CITY OF ALBUQUERQUE
PLANNING DEPARTMENT
April 9, 2014
DRB Comments

PROJECT # 1009853

APPLICATION # 14-70092

RE: Lot 6, Garden Acres

**PLAT OF  
LOTS 6-A AND 6-B  
GARDEN ACRES ADDITION**

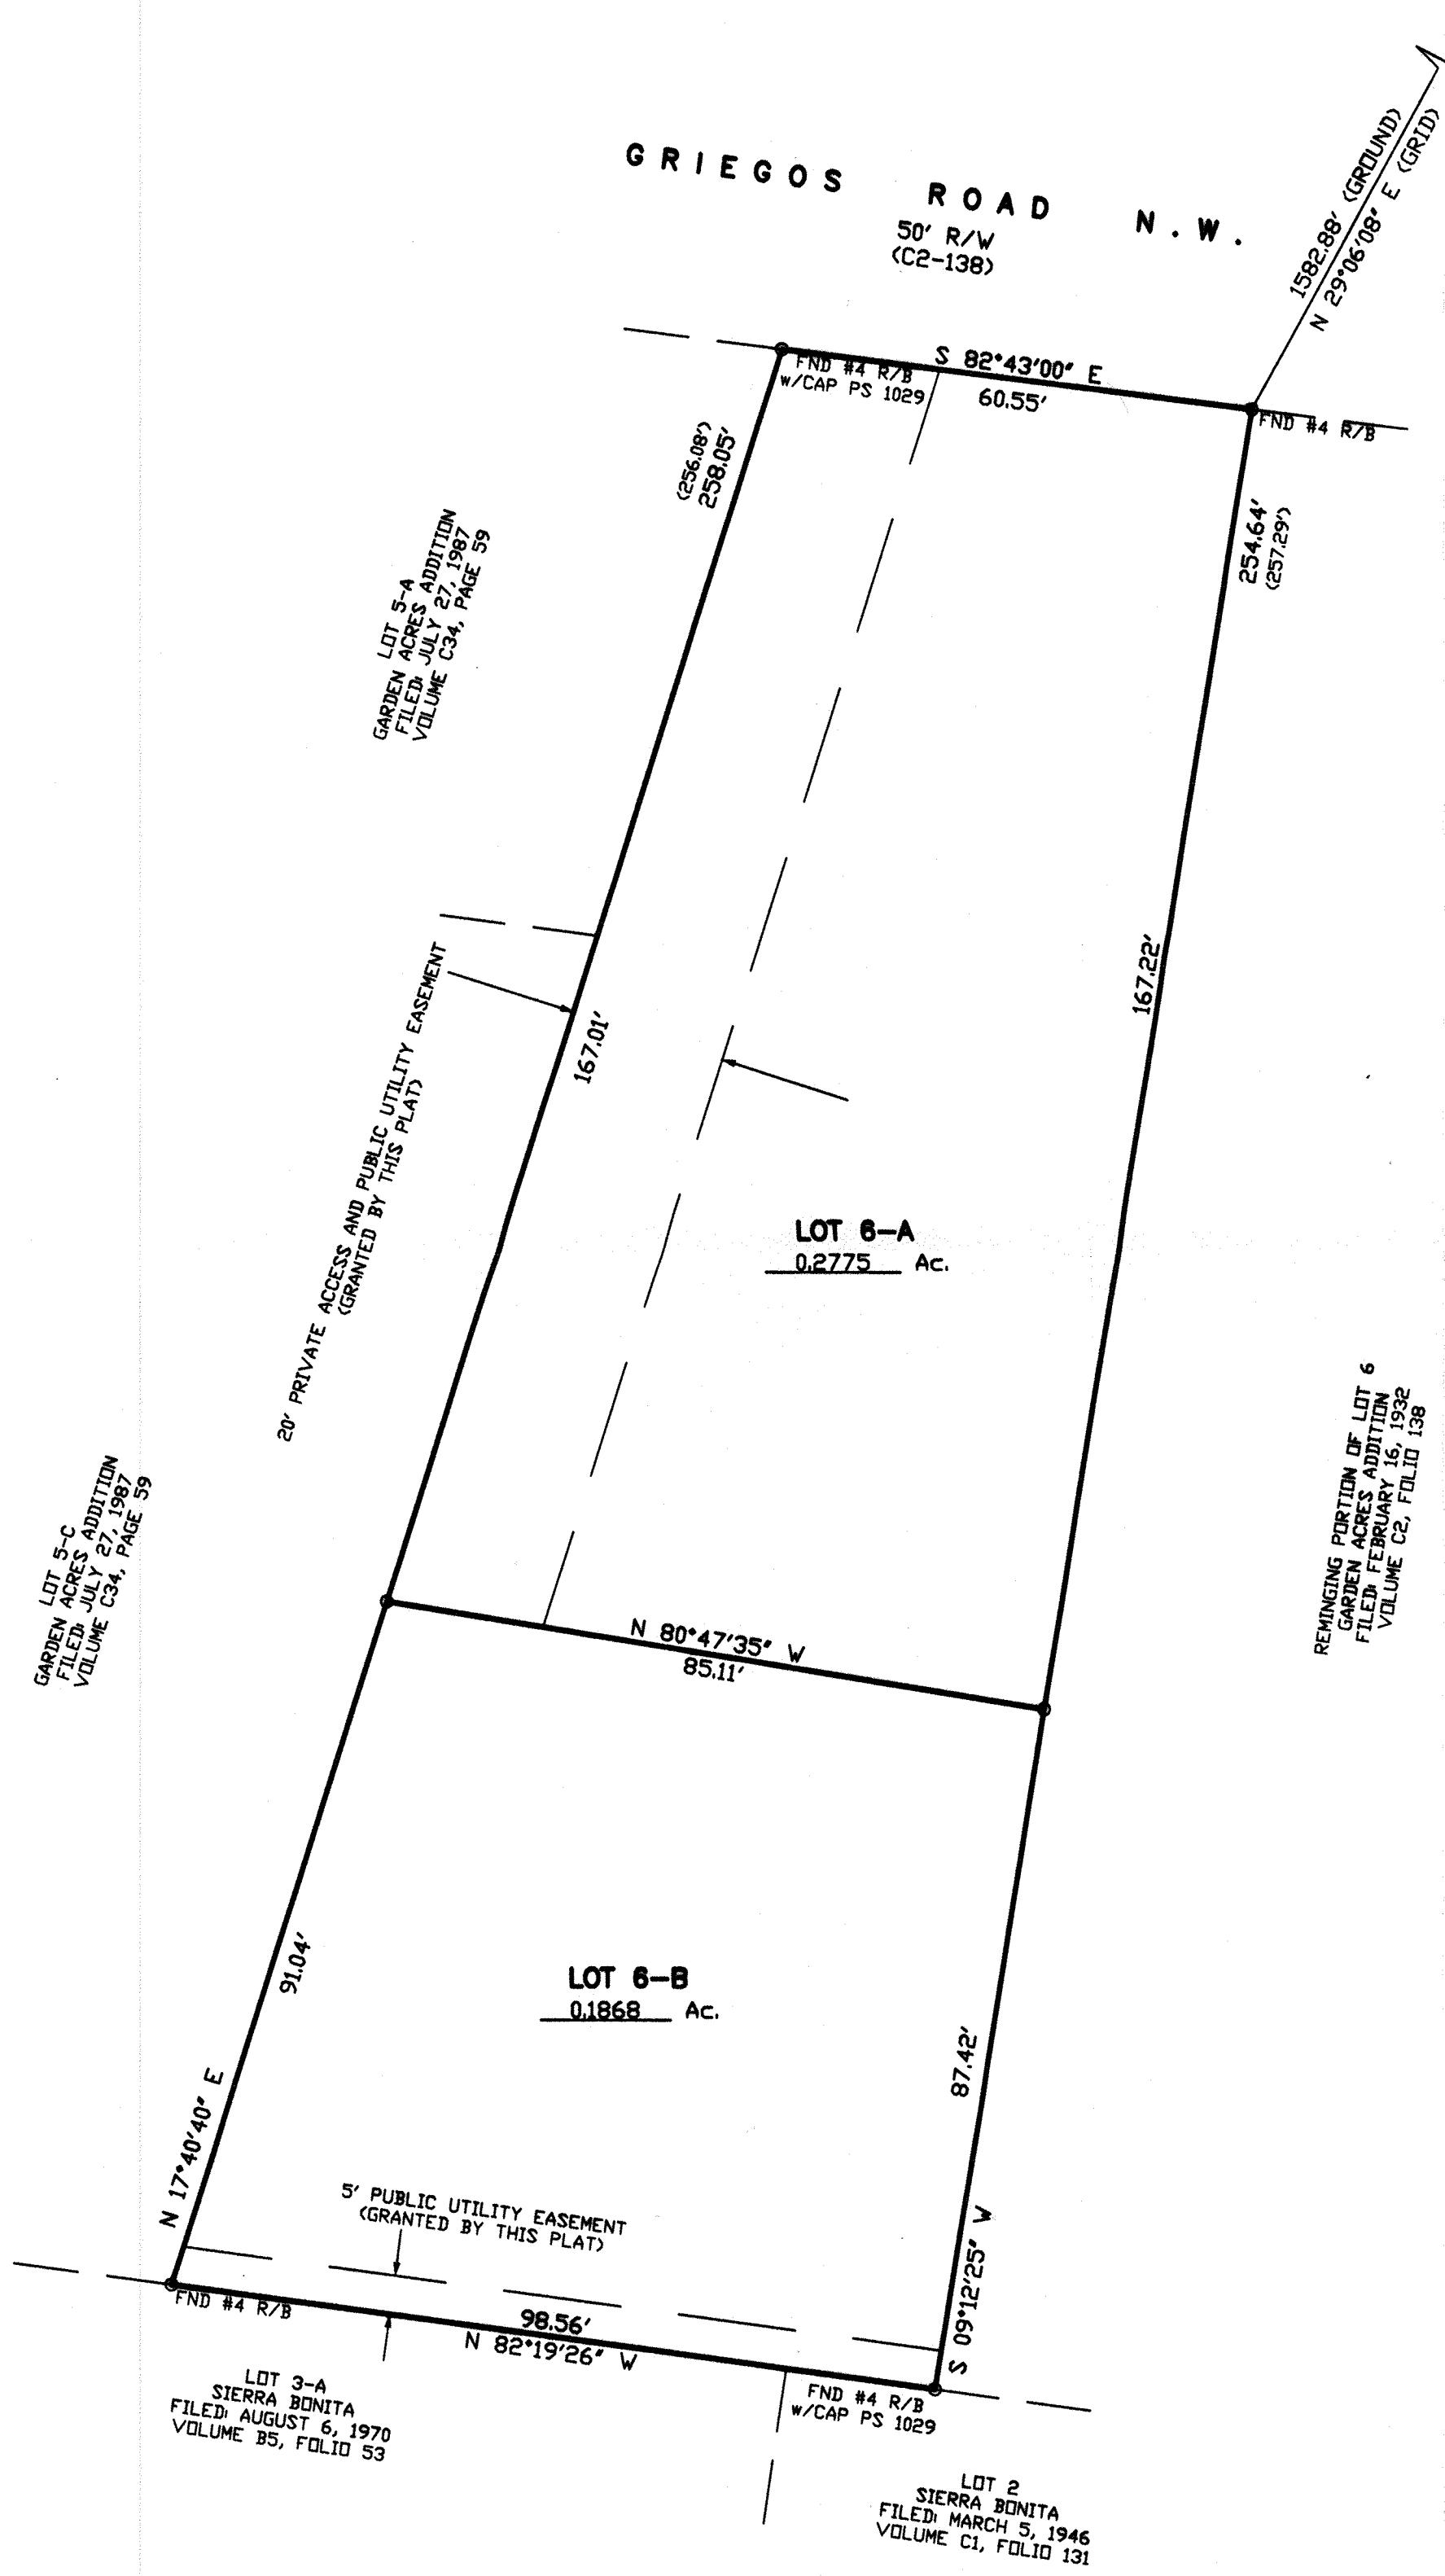
The proposed 20 ft Easement will likely need to be for Private Water and Sewer Service - refer to comments from ABCWUA; additionally, Maintenance and Beneficiaries need to be clearly noted on the plat.
